A Planning Application by
COMPLETE PLANT HIRE LIMITED

In respect of
**12 Southfields,
WELWYN GARDEN CITY**

Technical Note – Survey Summary

August 2021

Figure 2.3 Personal Injury Collision Data

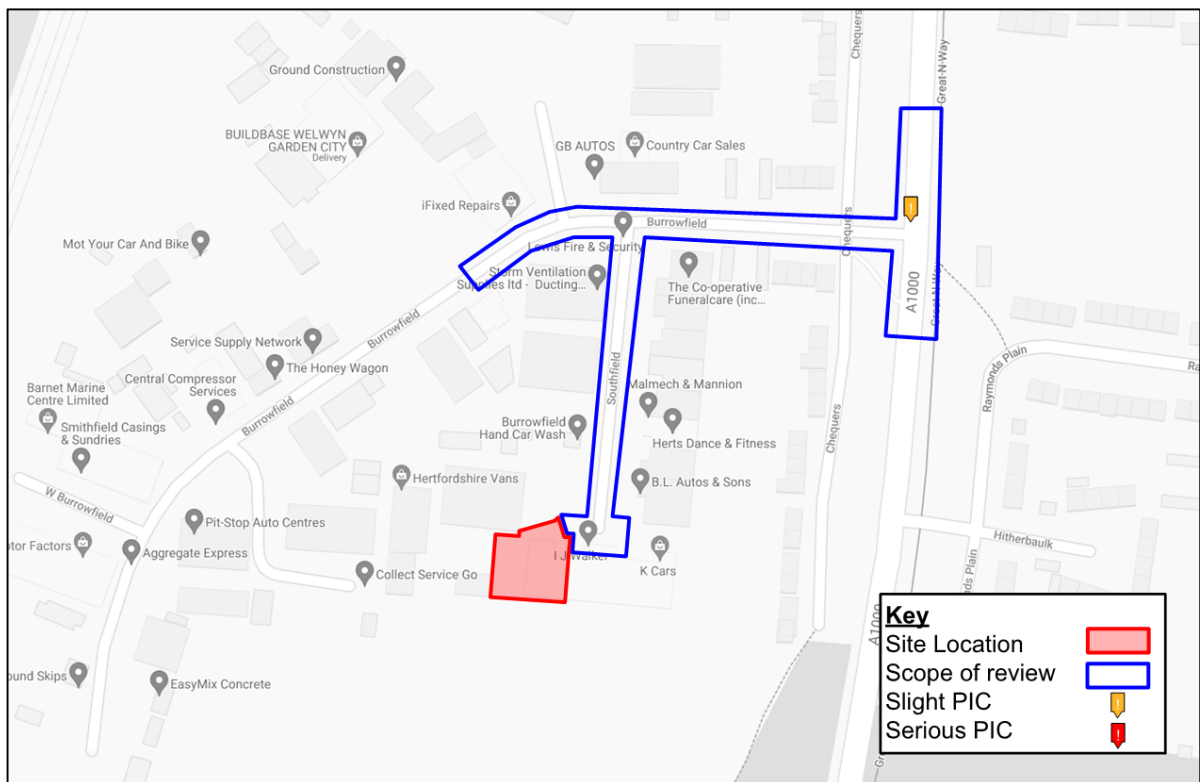
The Transport Technical Note has not included a review of personal injury collisions that have occurred on the local highway network over the most recently available five-year period of data. The Highway Authority request this is undertaken, and details of patterns/clusters of collisions must be provided.

2.17 Accordingly, a review of the personal injury collision (PIC) record for the local highway network has been undertaken, based on the most recent five years of data obtained from Crashmap. The data, summarised in **Figure 2.3**, shows that only one slight PIC has been recorded in the five year period between 2016-2020. As can be seen, this incident took place on the A1000 close to the junction with Burrowfield and at some remove from the site.

- 2.18 A single PIC within the last 5-year period does not indicate that there is any significant highway safety issue in the vicinity of the site. It is also the case that the current use of the site has been in operation for 5 years and it is understood that the PIC identified did not involve a vehicle associated with Complete Plant Hire Ltd.

TITLE:
**SWEPT PATH ANALYSIS OF
 A 26t RIGID VEHICLE**

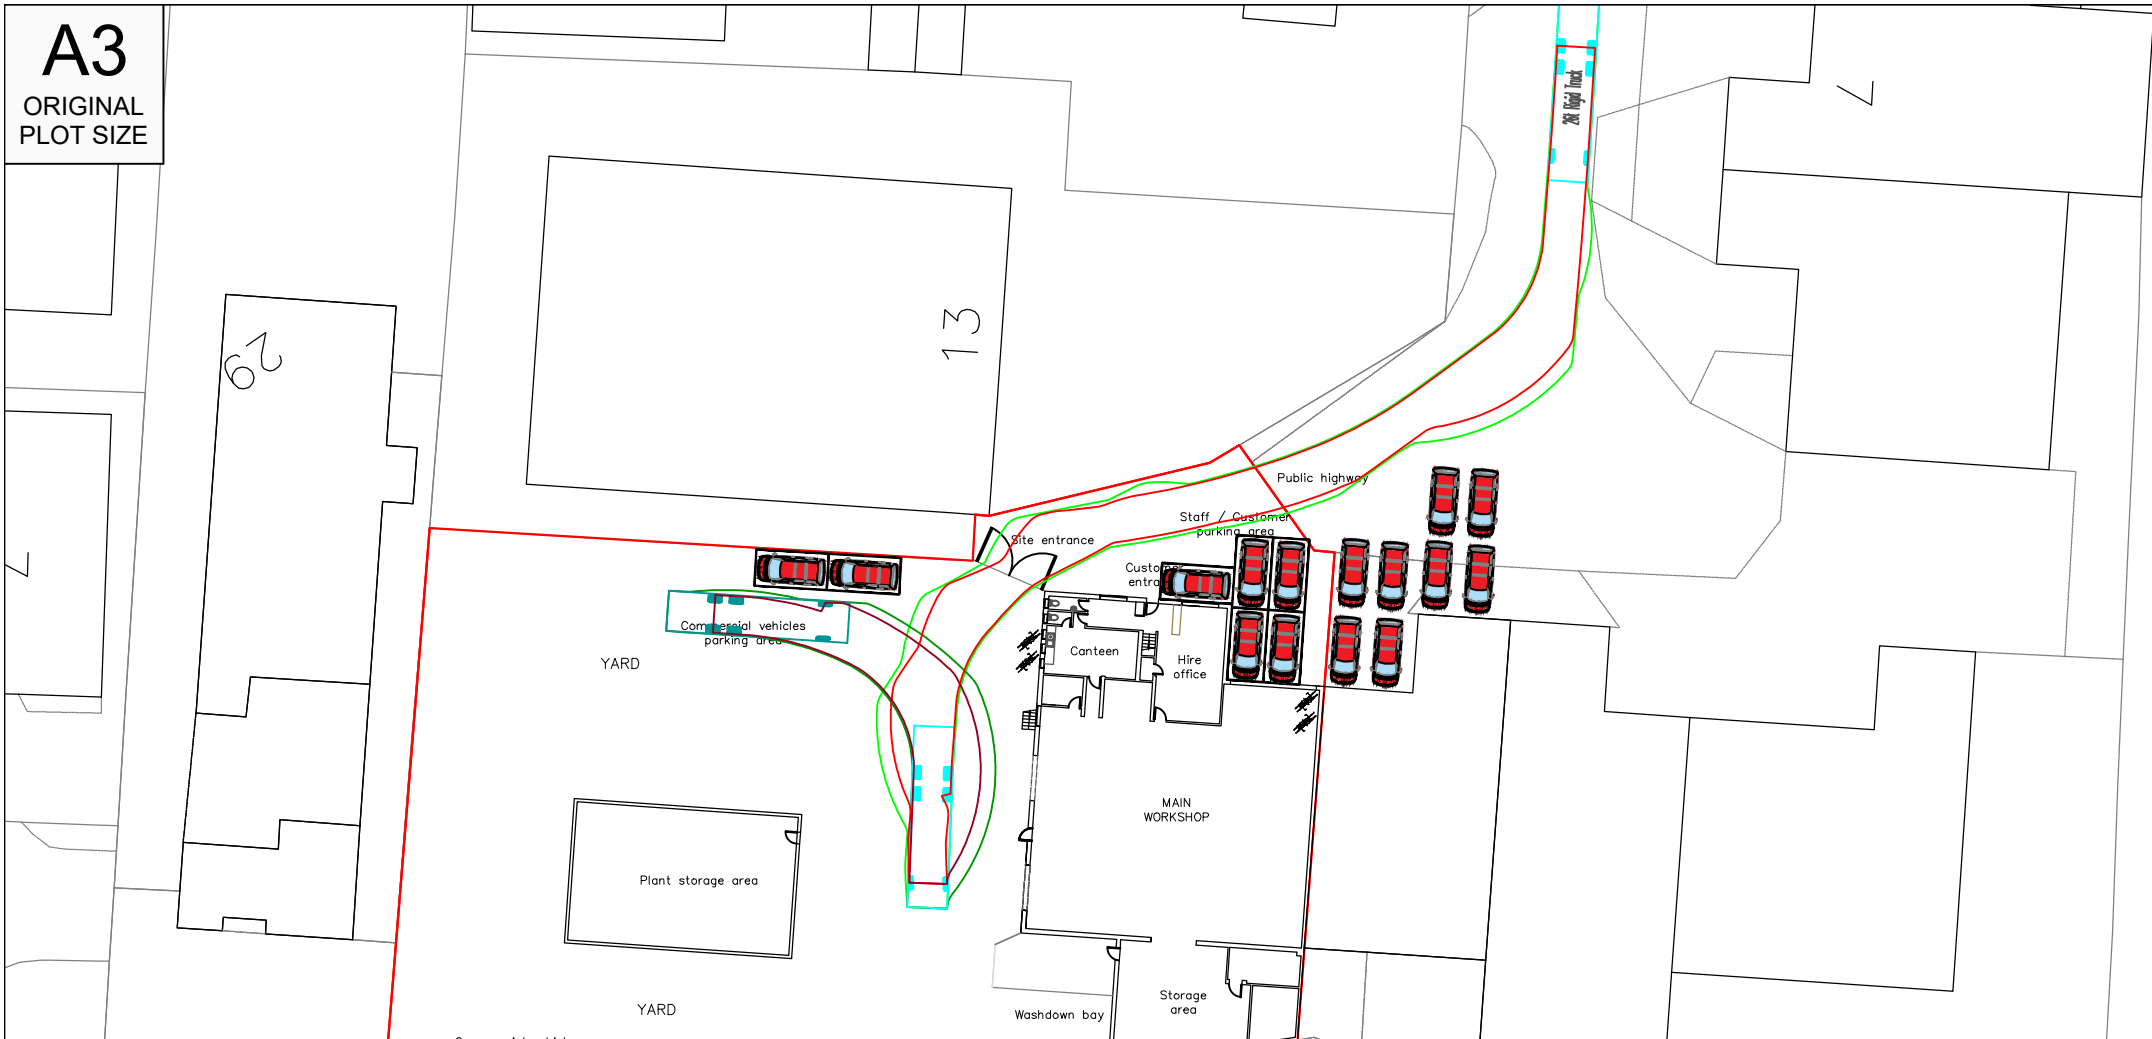
The Highway Authority are concerned that the Transport Technical Note contained only limited details of the types of vehicle that access the site and therefore the swept path shown in Drawing No. SP01 may not be representative of the largest vehicle that will commonly use the site (i.e. lengths of low loaders and articulated vehicles). Without these details there is a highway safety risk that large vehicles may reverse long distances on the public highway.

2.10 A swept path analysis of a 26 tonne vehicle has been undertaken and is contained within **Appendix C**. As can be seen, the vehicle can enter and exit the site in forward gear. This manoeuvre can be seen in the CCTV survey.

EXISTING PARKING
PROVISION

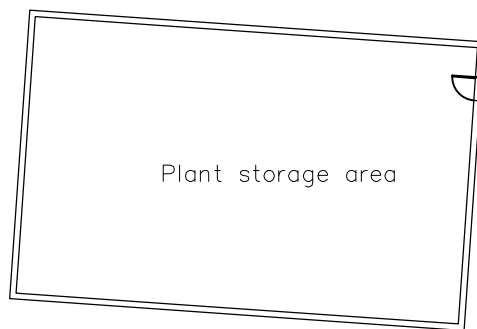
There is also a concern that the details of formal on-site car parking arrangements have not been provided or shown on a plan. Therefore, the turning area of vehicles in the yard may be blocked by informal parking.

The applicant has provided no details of the number of on-site car parking spaces, nor details of cycle parking provision.

Cycle parking must also be provided. The HCC Local Transport Plan requires all sites to provide cycle parking provision.

2.14 As shown, the parking associated with the site does not impact upon the access arrangement for the site itself, which is located at the end of a service stub from Southfields. Notwithstanding this, a plan has been prepared that shows the cycle and car parking used by the site, which is reproduced at **Appendix D**.

2.15 As can be seen, the site will provide a total of four cycle parking spaces, comprising spaces within the yard and two spaces within the building.
